Subject: Objection to AW/337/19/A from The Aldwick Community Society

OBJECTION TO : AW/337/19/A . One Stop Store Application for signage on the Ship Inn site

FROM: THE ALDWICK COMMUNITY SOCIETY

PROPOSED SITE SIGNAGE

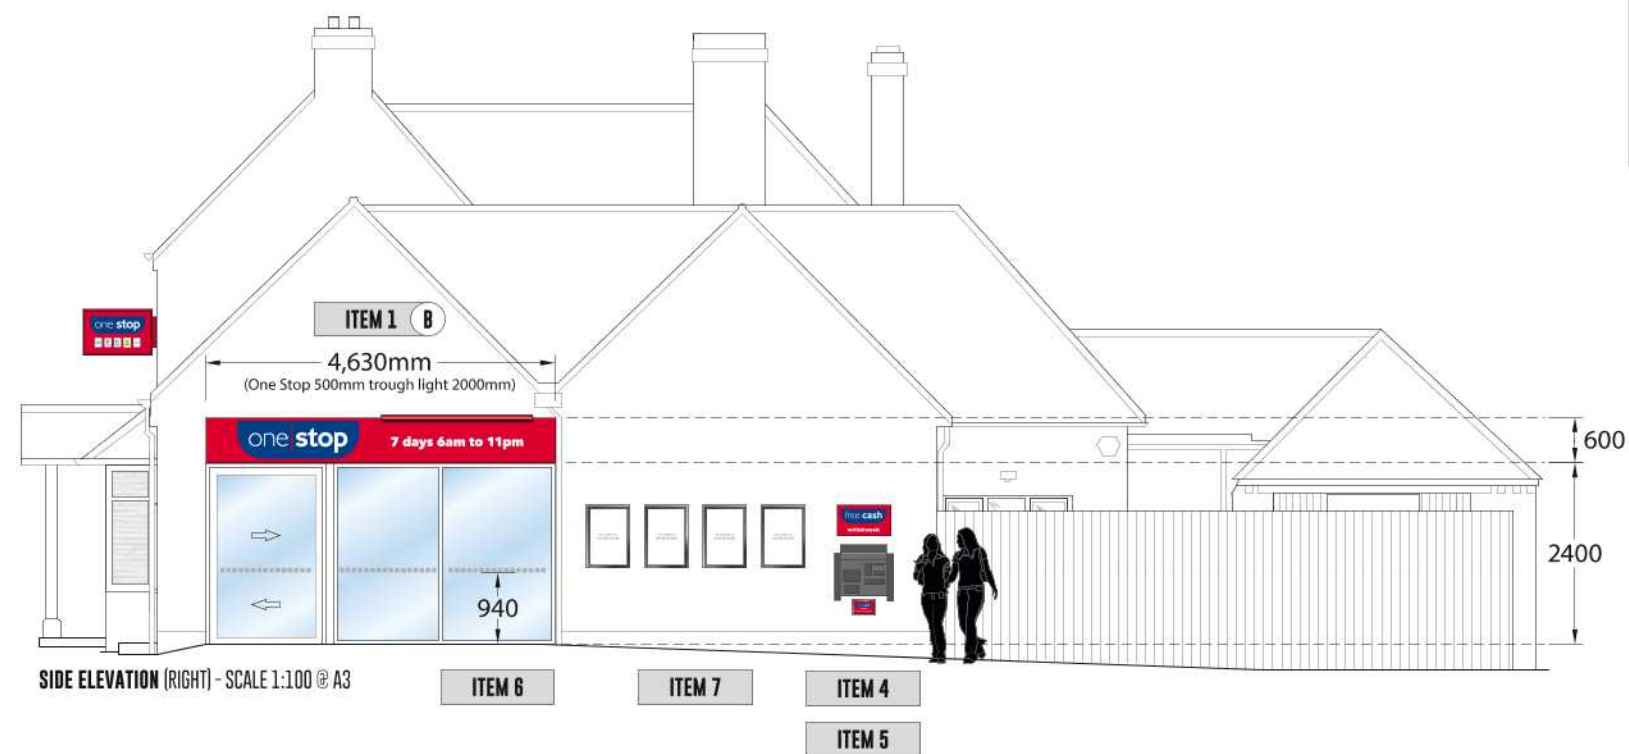
The planning application seeks to erect inappropriate signage on the Ship Inn pub building and site, designated with Arun DC as an Asset of Community Value. The building is also recognised as of "special character" but the signage and its garish livery will degrade the building. It is out of keeping with the surroundings and the accompanying lighting will pollute the environment in the hours of darkness.

PROPOSED SITE SIGNAGE

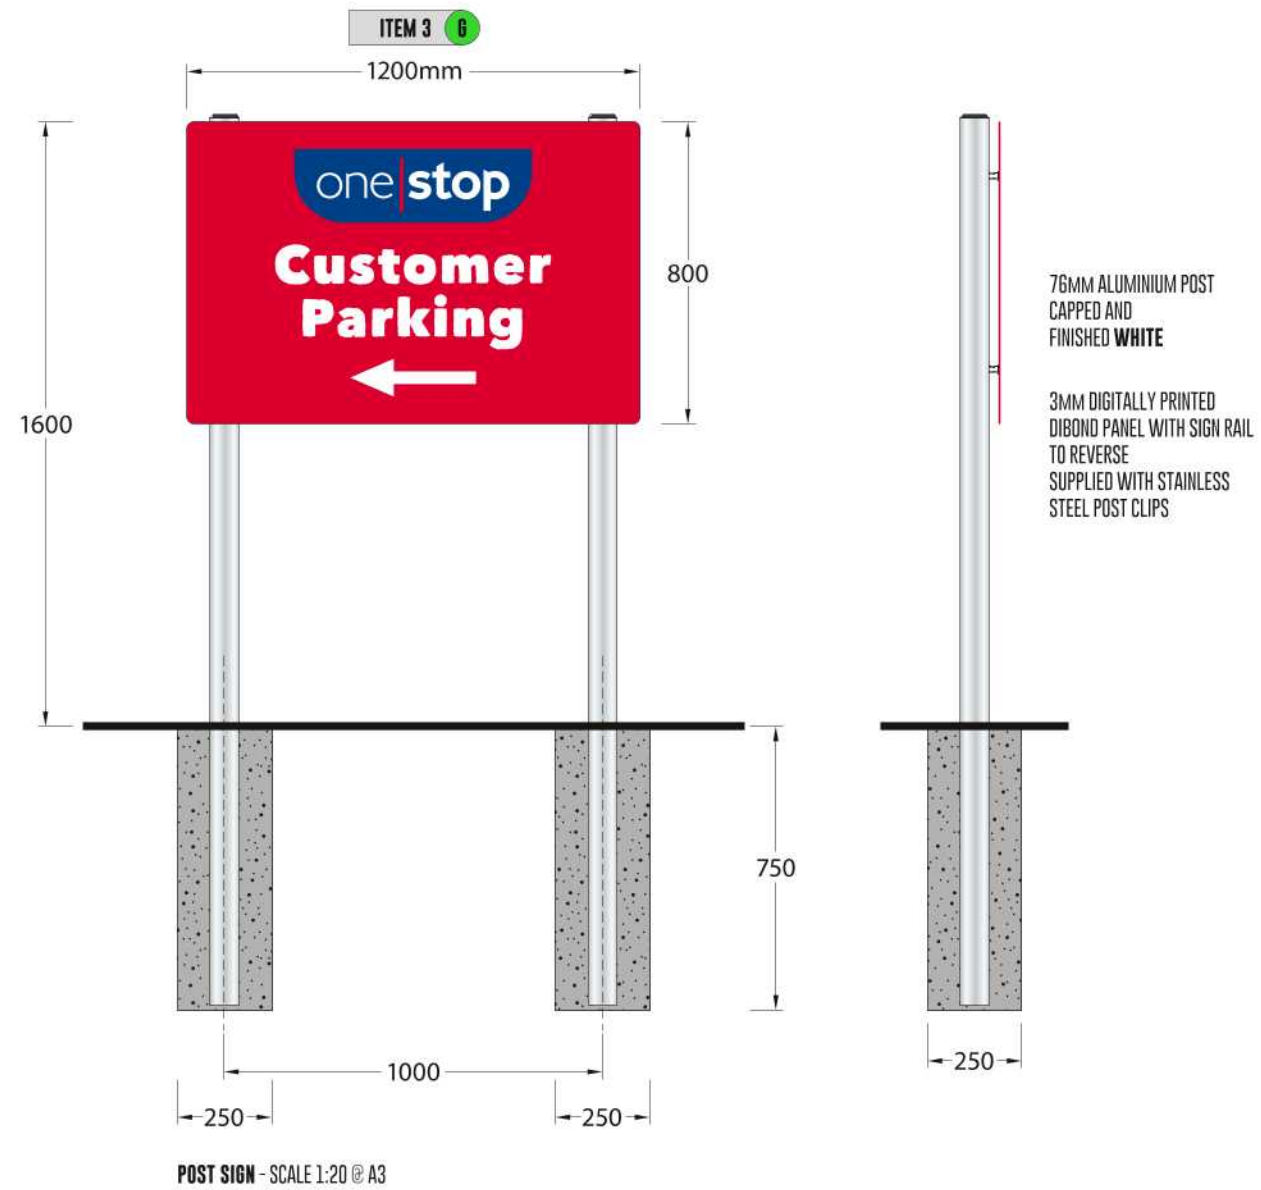
The proposed panels covering the bay windows disfigure the building and are out of character with the parade of shops on the other side of the road. There is also one extra panel proposed on the eastern end of the front elevation.
